Your Ref :
Our Ref : LU/91/12/NMA

Application for non-material amendment following LU/336/11/ - solar panels & windows
29 Buttermere Way, Littlehampton, ,

SHEET 3 OF 6

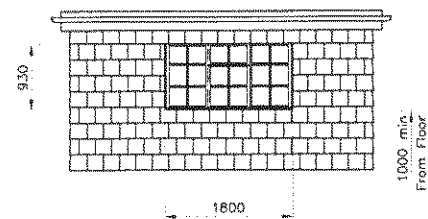
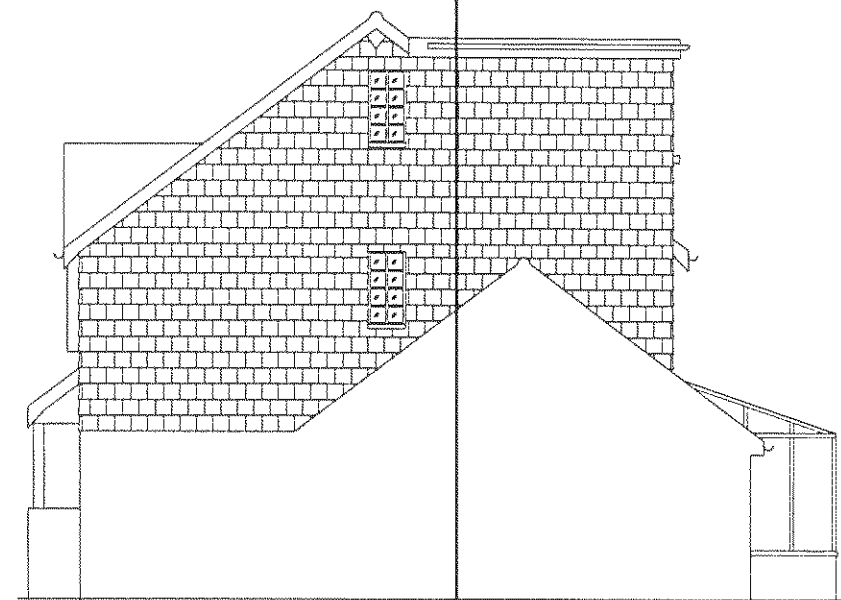
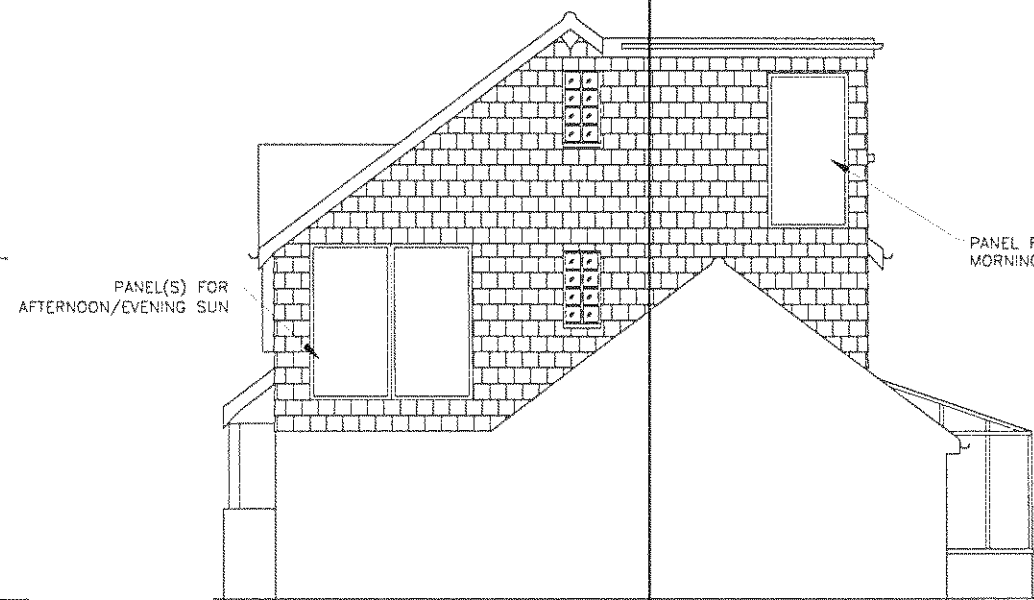
The changes identified within Drawing No. BW029/1 Sheet 3 of 6 namely the introduction of 1No. window within the dormer extension to replace the two approved and the inclusion of two arrays of solar panels on the south elevation of the dwelling will be accepted as Non Material Amendment to the previous planning approval.
